Oaklands Farm Solar Park

Consultation Report

Appendix 13.1 - Section 42 Copies of Responses and Summary of
Feedback and Regard Had

Document Reference: EN010122/APP/5.2

3200-3299/3299 Oaklands Solar Farm/Project Files/CAD			
	A	MJ	16.08.23

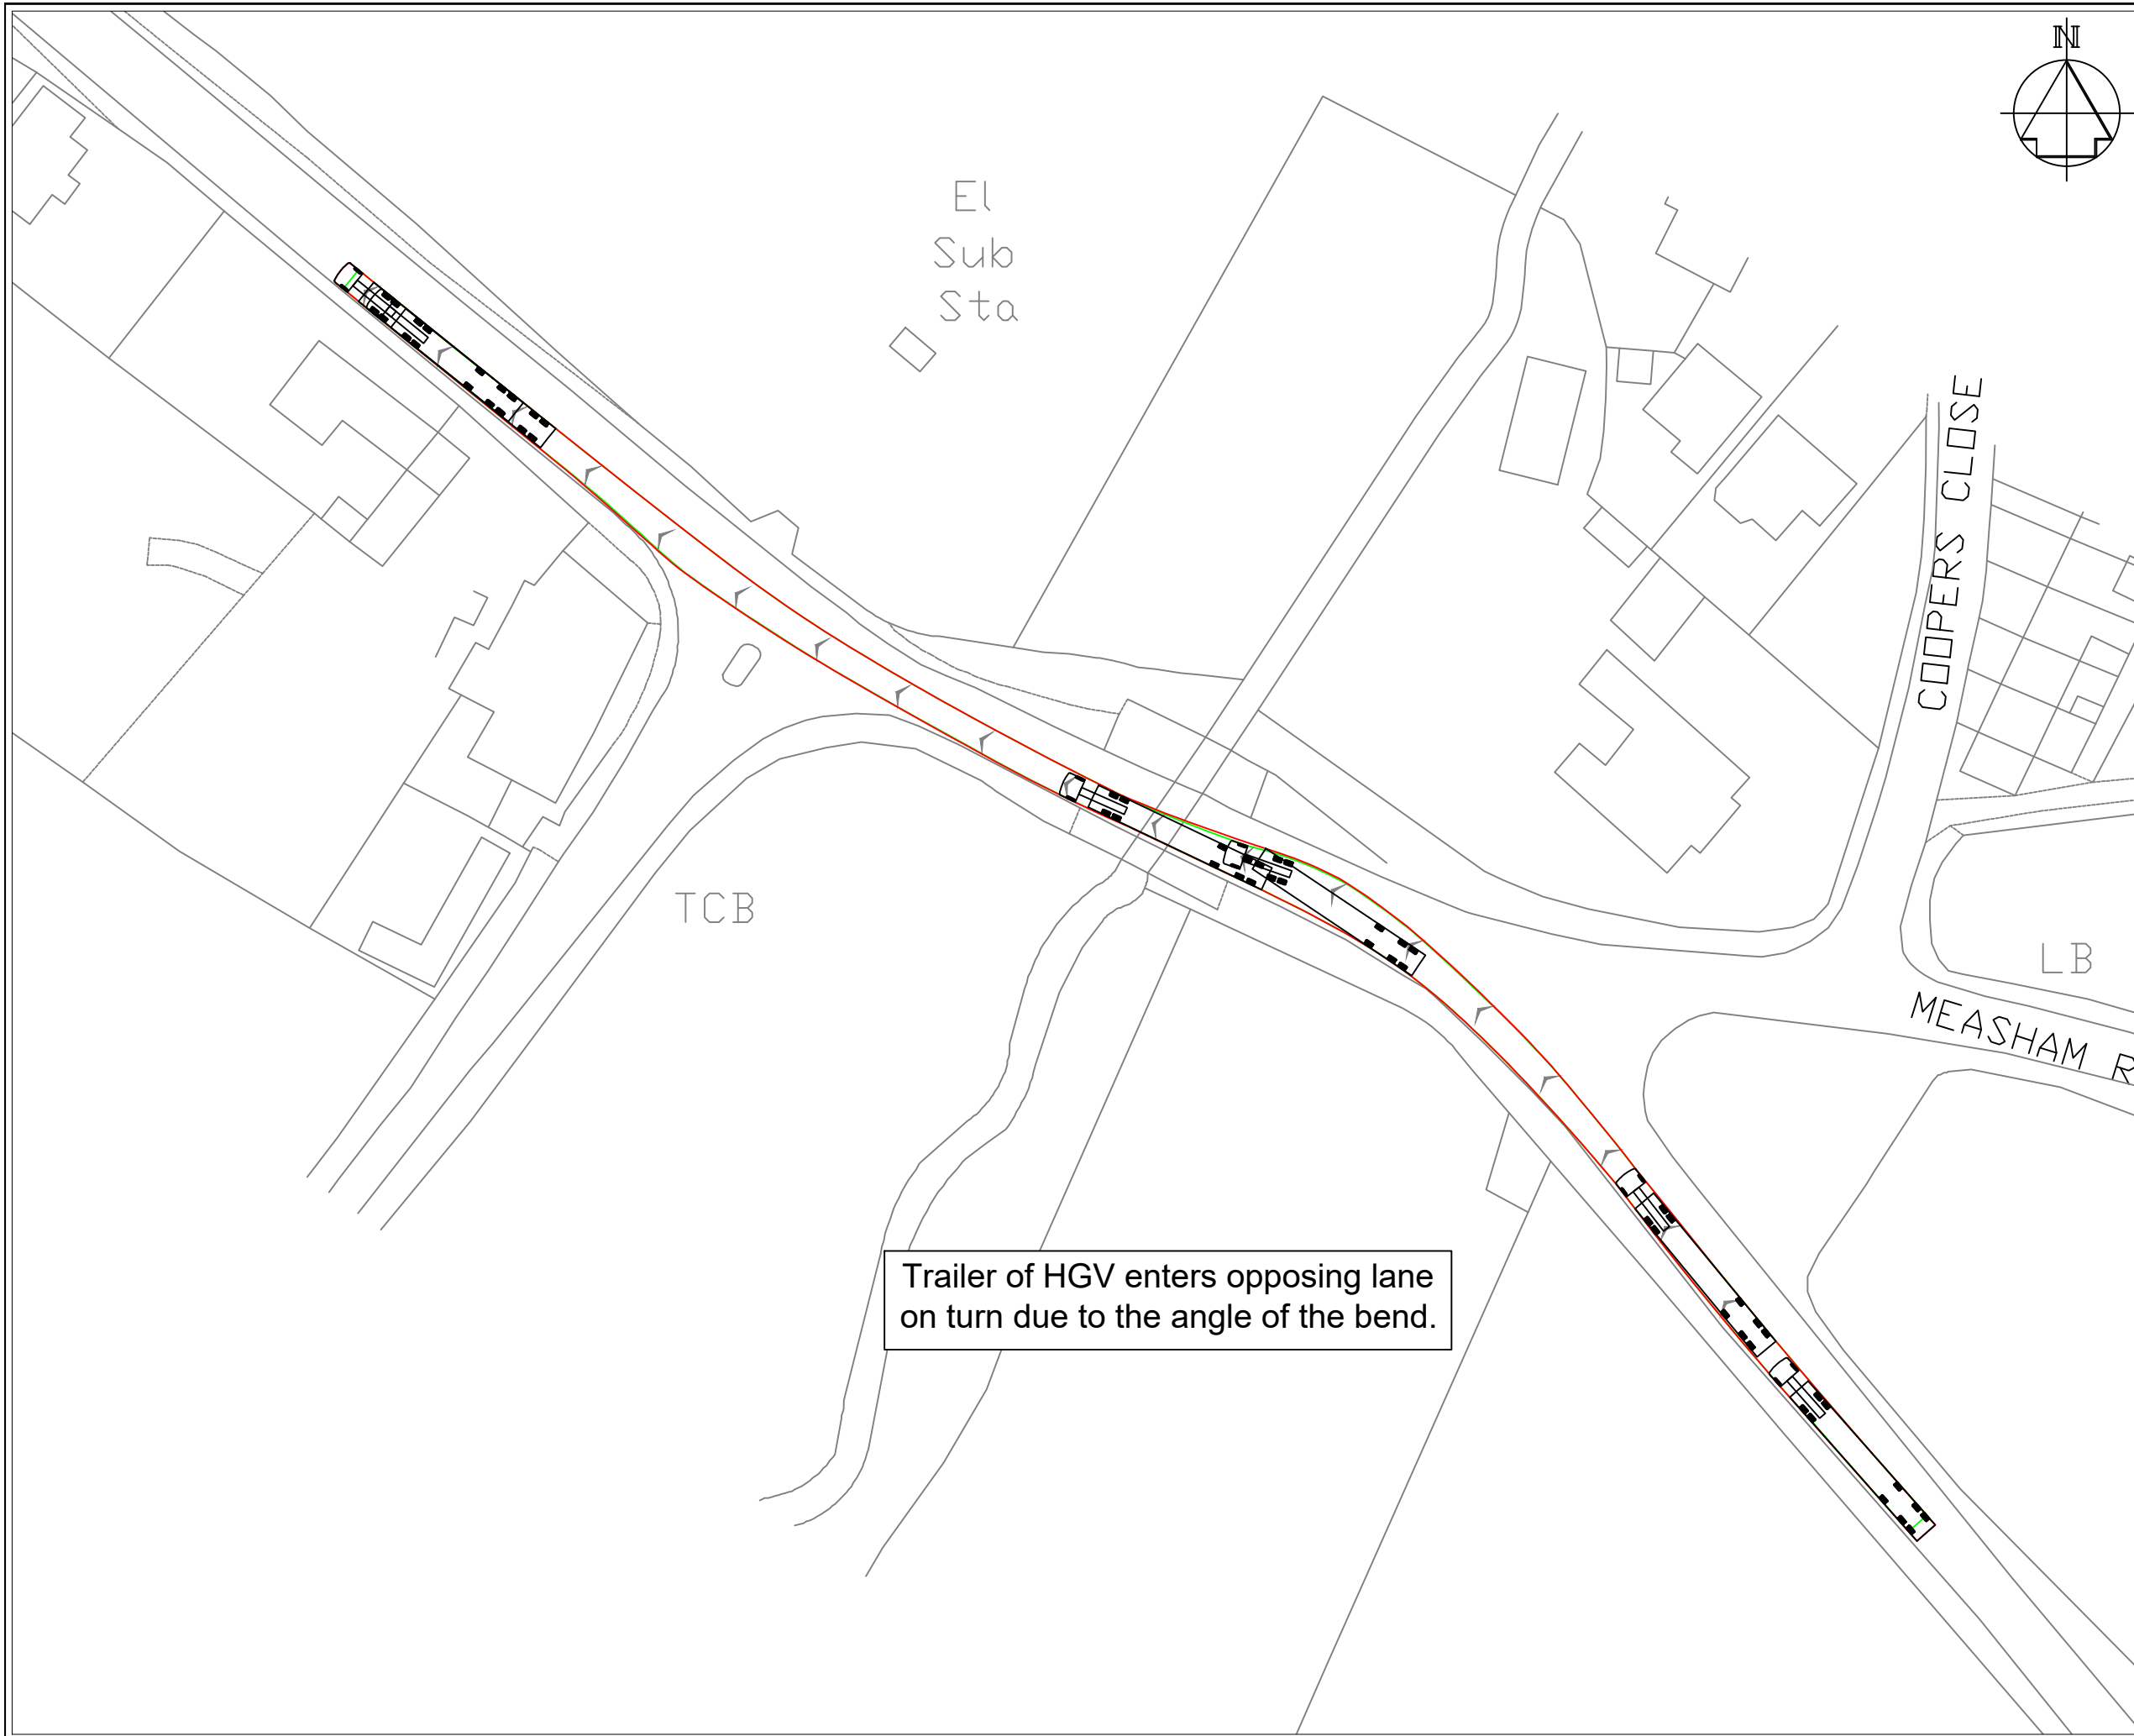
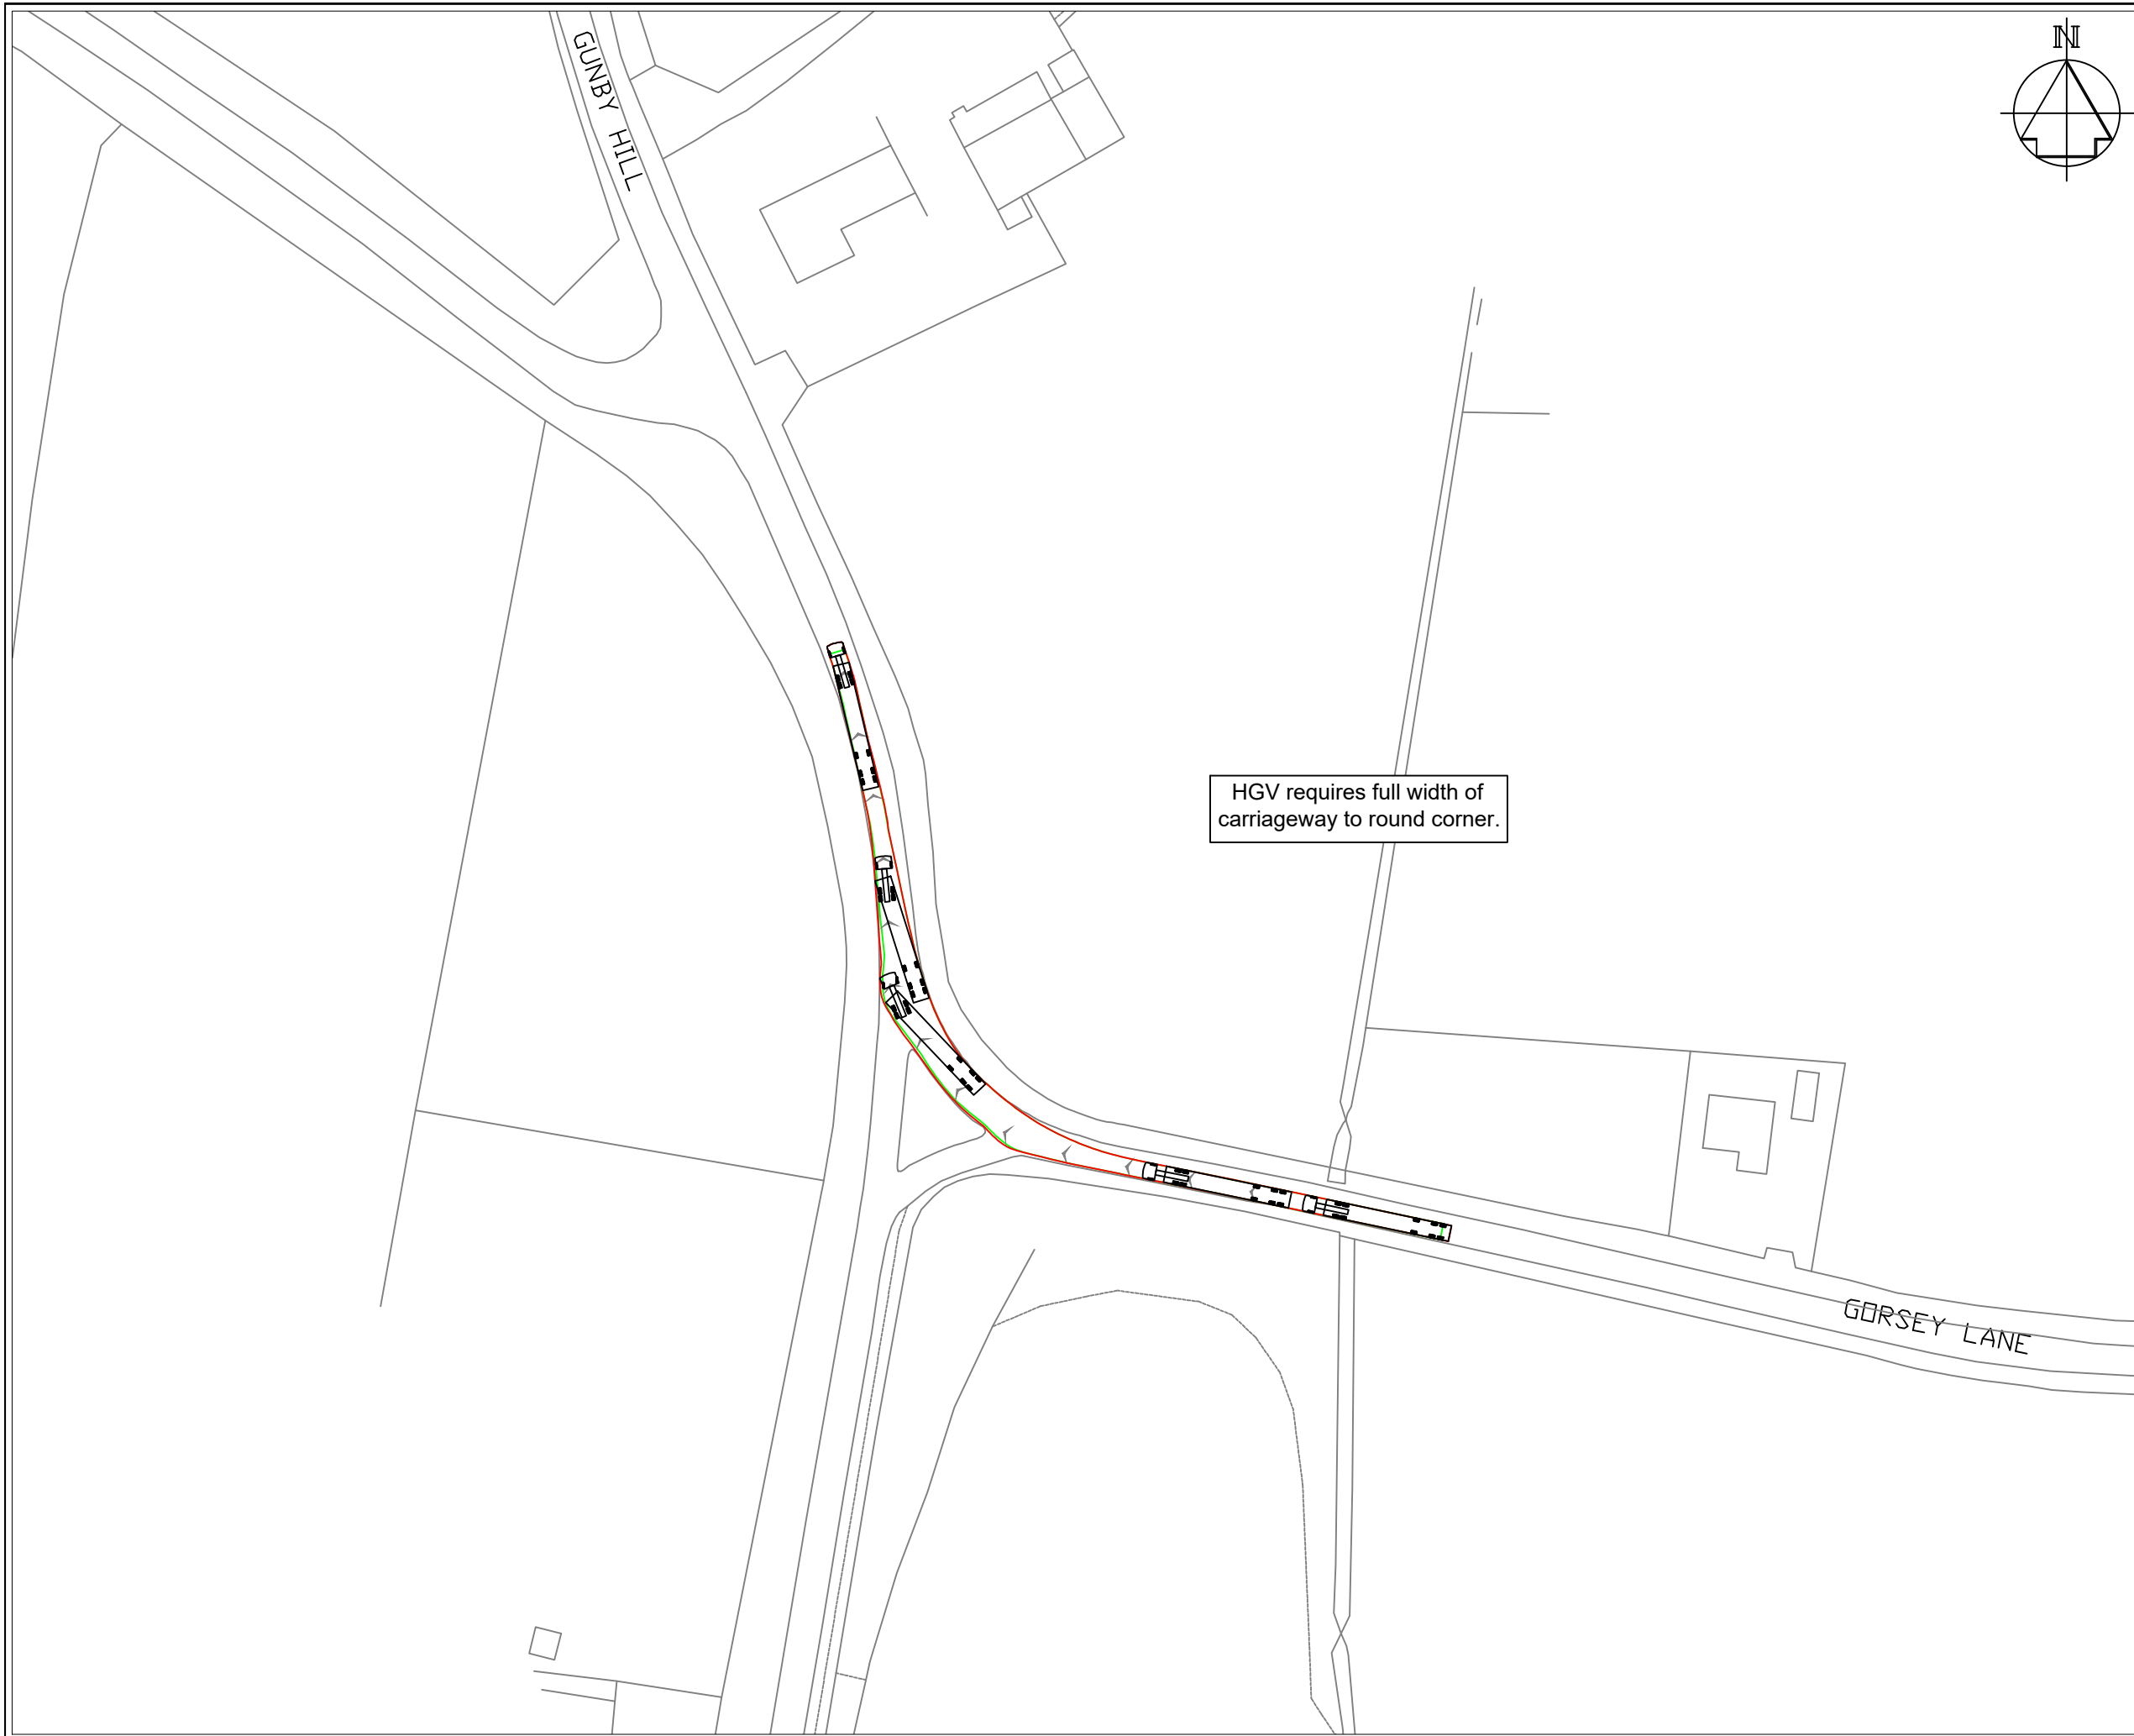
- Request for further information including swept path analysis of access points to the site to assess suitability or any highway safety concerns.
- The CEMP should clarify whether any safety issues should be considered during operation, although it is noted that vehicle movements at this point will be minimal.
